Our Ref: EN010068

Date: 5 March 2015

## **MILLBROOK POWER PROJECT**

### **DRAFT HABITATS REGULATIONS ASSESSMENT: NO SIGNIFICANT EFFECTS REPORT**

Figure 1: Location of European Sites

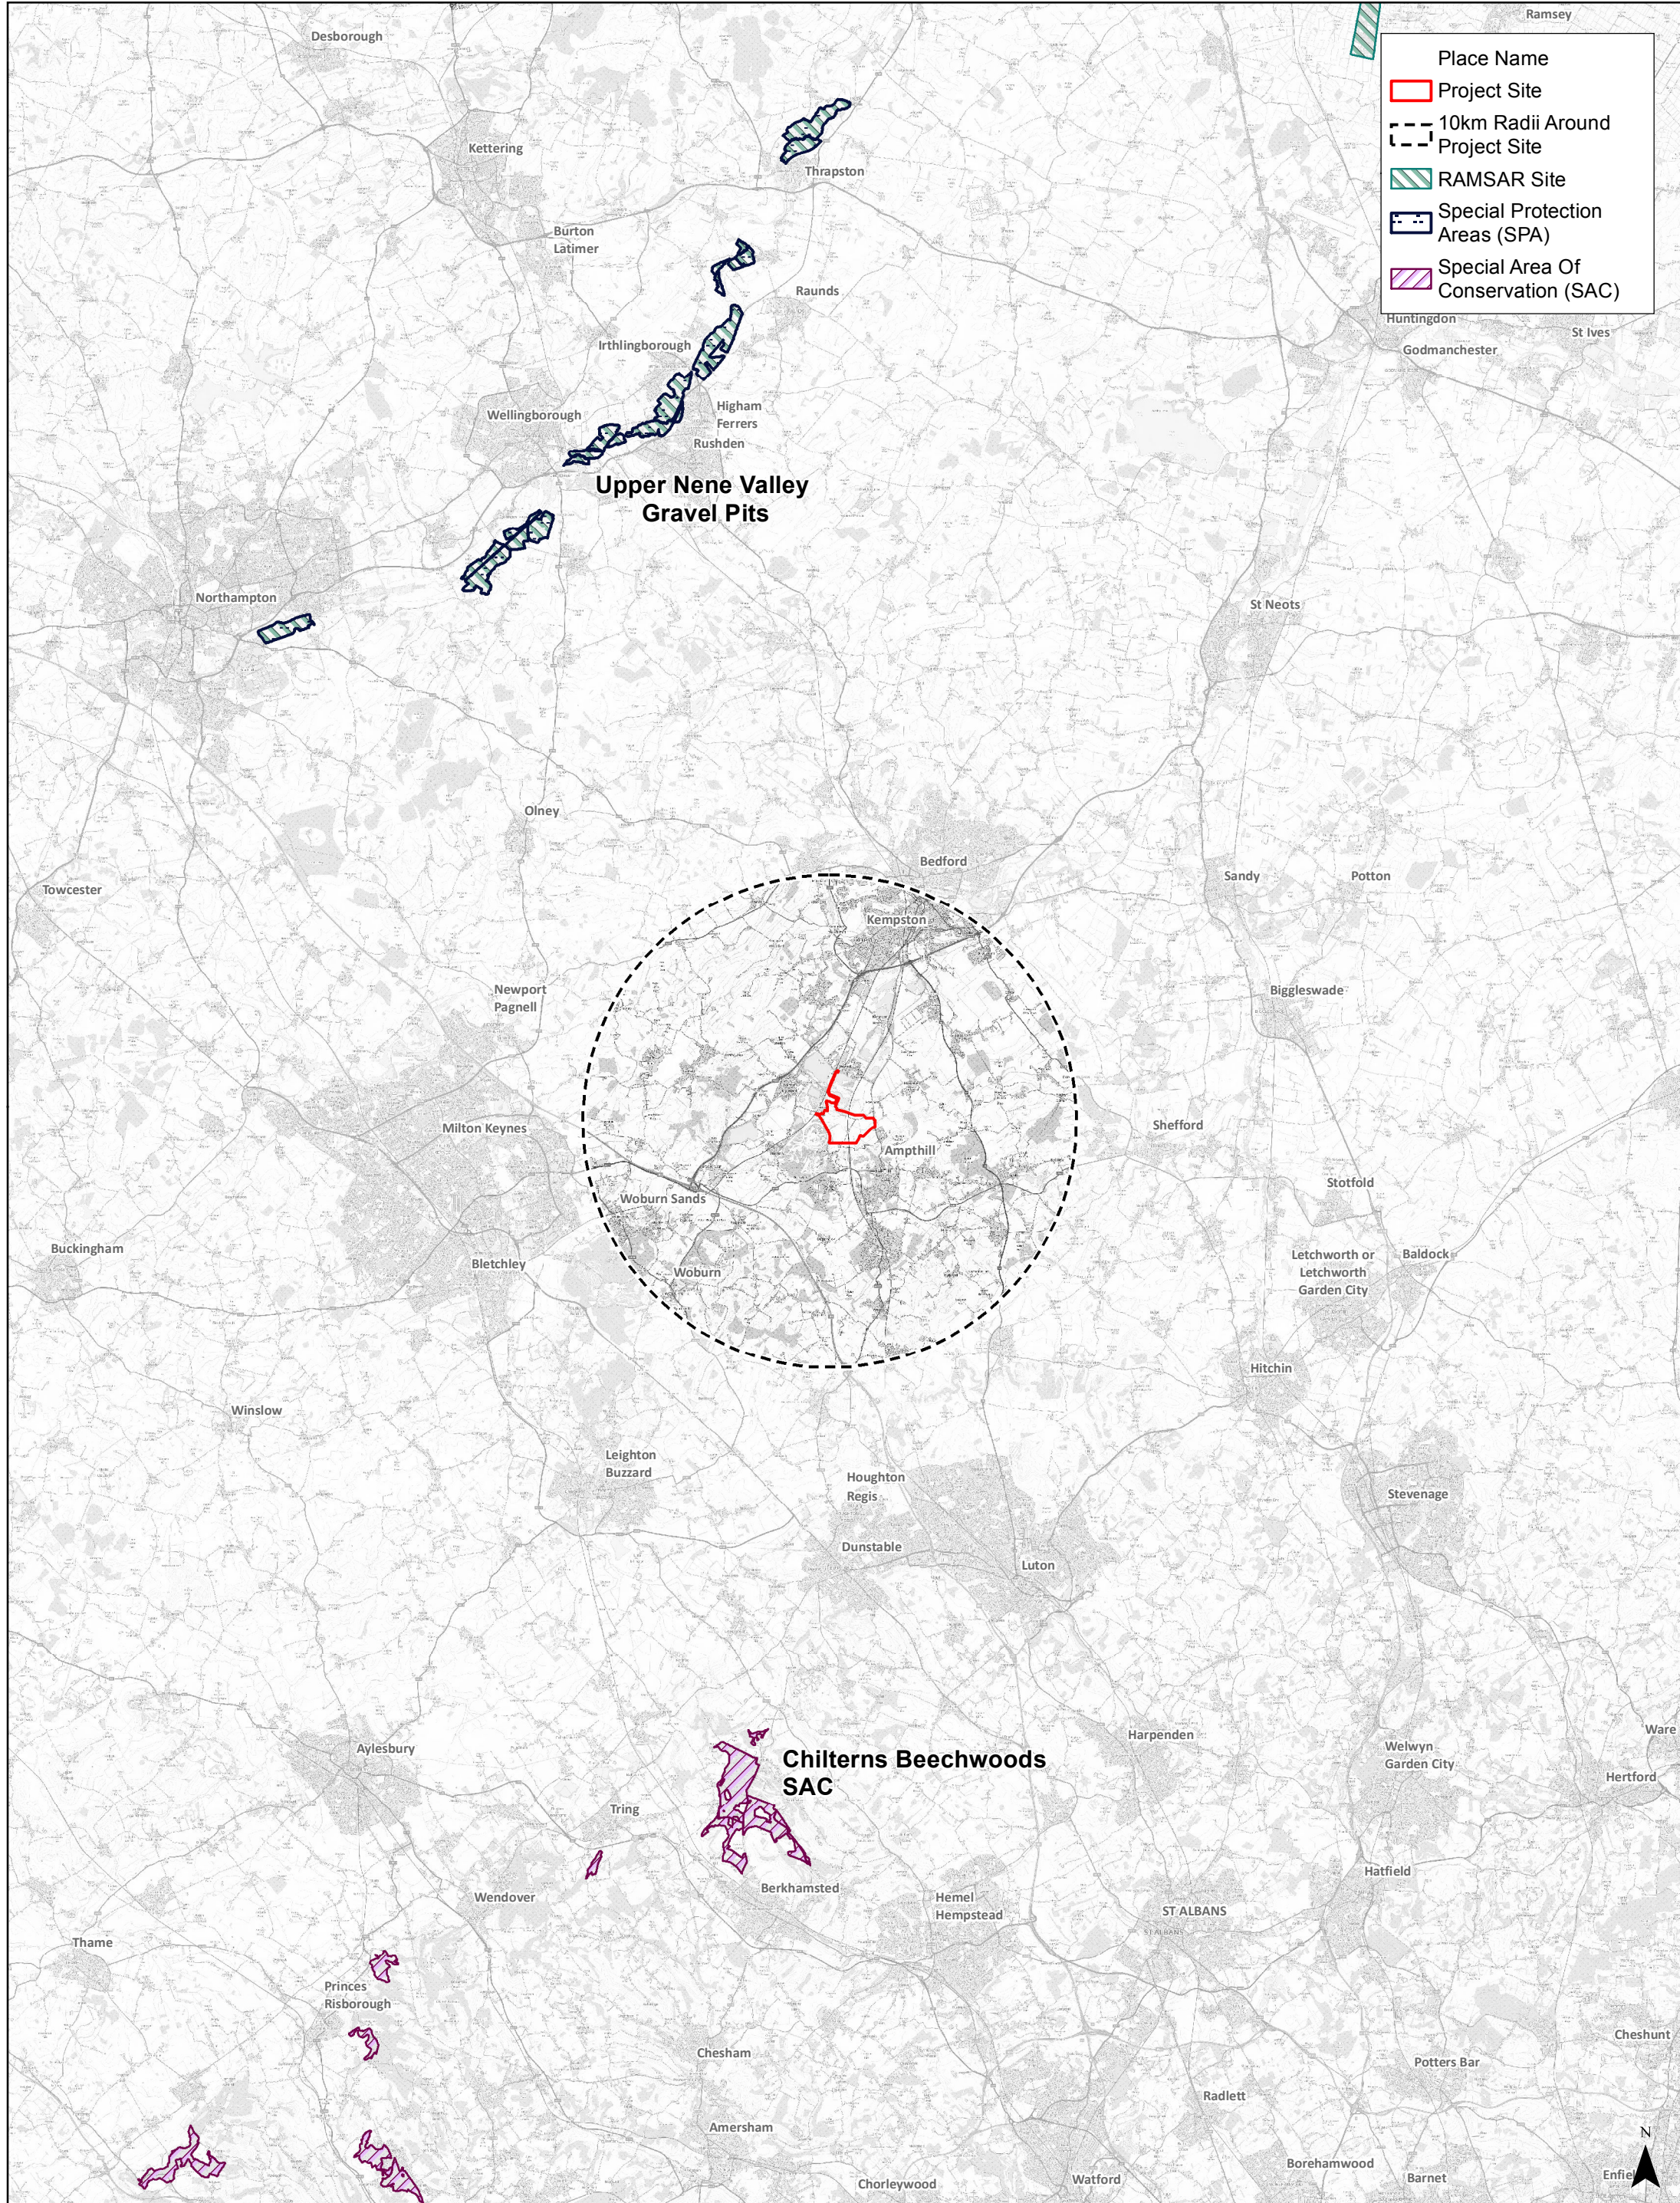
- Paragraph 1.1.12: suggest cross-referencing to a site/location plan would be helpful;
- Paragraph 1.3.3: Figure 1 is not included in the Report.
